**KIRKLEES METROPOLITAN COUNCIL
INVESTMENT & REGENERATION SERVICE**

DELEGATED DECISION TO DETERMINE PLANNING APPLICATIONS

Reference No:	2021/62/94052/W
Site Address:	former police station, Bradford Road, Fartown, Huddersfield, HD2 2QF
Description:	Erection of extension and alterations to convert former police station to offices
Recommending Officer:	John Holmes

DECISION - REFUSED

Drawing title  
**EXISTING ELEVATIONS**

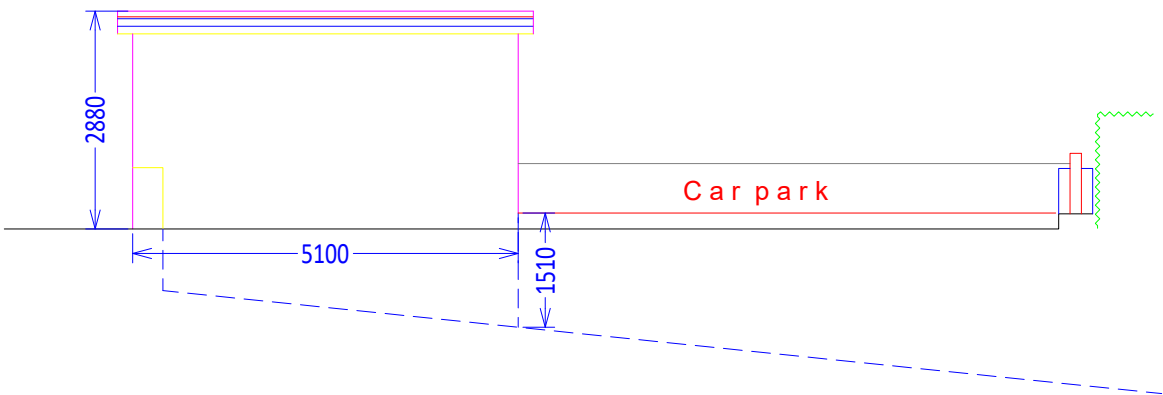
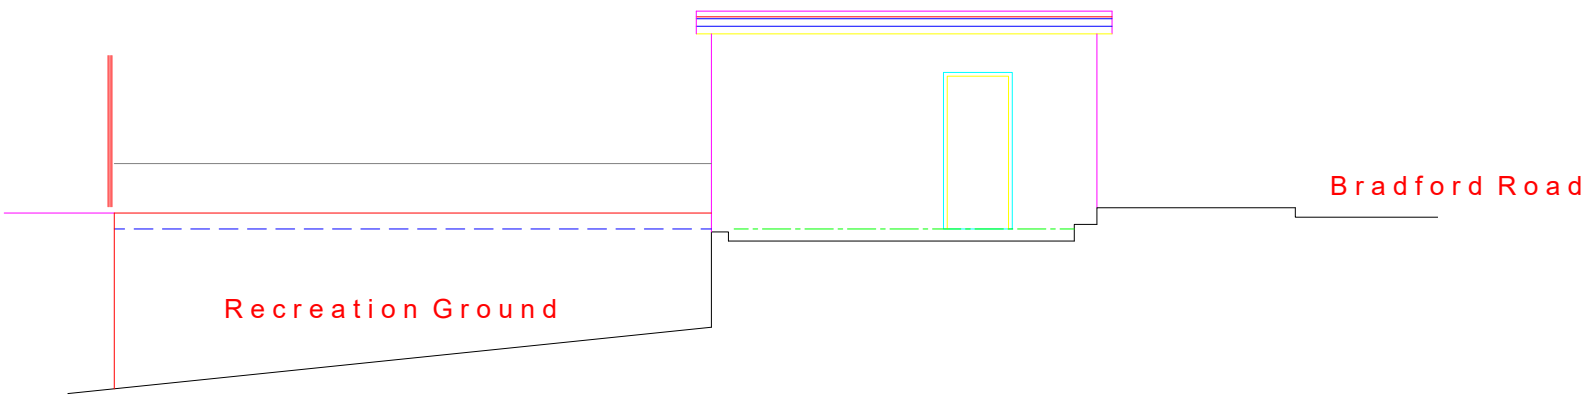
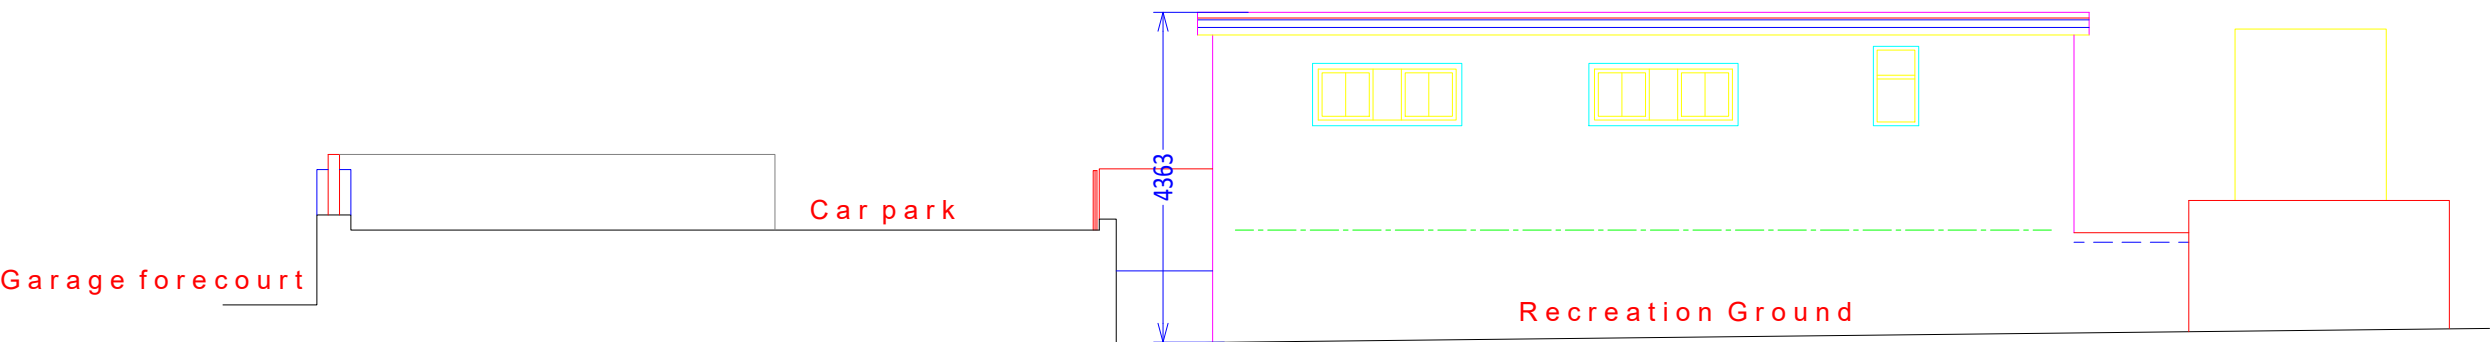
The building would increase from a footprint of 11.3m x 5.1m to 14.3m x 5.1m. and from a flat roof building 2.6m in height to a two storey building with a gable roof which is 5.9m in height to the eaves and 8.5m in height to the ridge.

The proposal would see a large building which is in a prominent location on Bradford Road which is a key route into Huddersfield. It is considered that it would dominate the street given its proximity to the road, with the building being immediately adjacent to the back of the footpath and also the scale / massing of the building which is proposed.

The building would have a wide frontage which is dominated by brickwork. The gable roof design and small window sizes add to this bulk / massing which would be in this prominent location. It is considered that the previous reason for refusal has not been overcome in terms of scale, siting, form, and architectural features.

It is considered that the proposal would have an incongruous appearance within the street and would be out of character with the locality given its scale and design with small windows and large amounts of brickwork in close proximity to the highway and within a visible part of the street.

FIRST FLOOR PLAN - PROPOSED 1:100

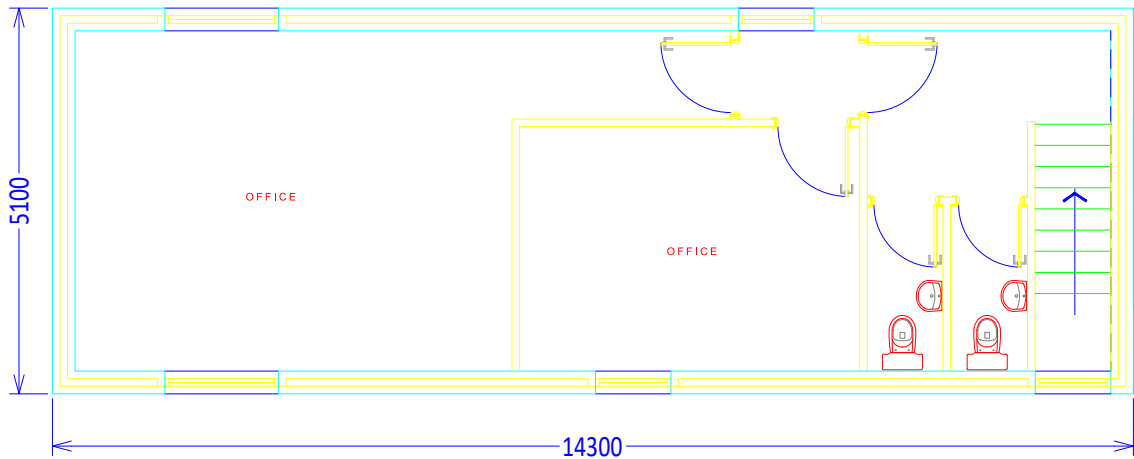
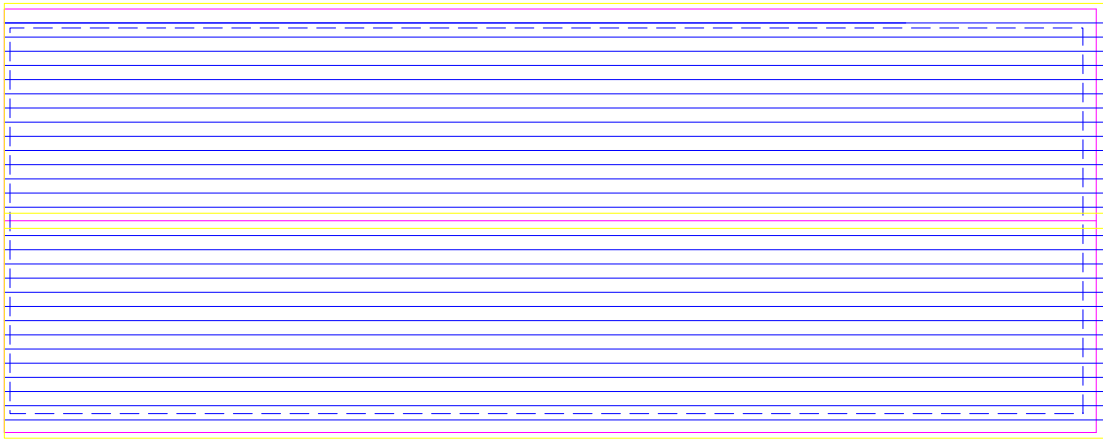
It is noted that there is a reference to separate entrance and stairs to student flats at first floor upon drawing 2102-AL-04revA, a request this be removed / amended has not seen an updated version of this plan forthcoming. Notwithstanding this it is considered the LPA can still determine this proposal whilst noting this error.
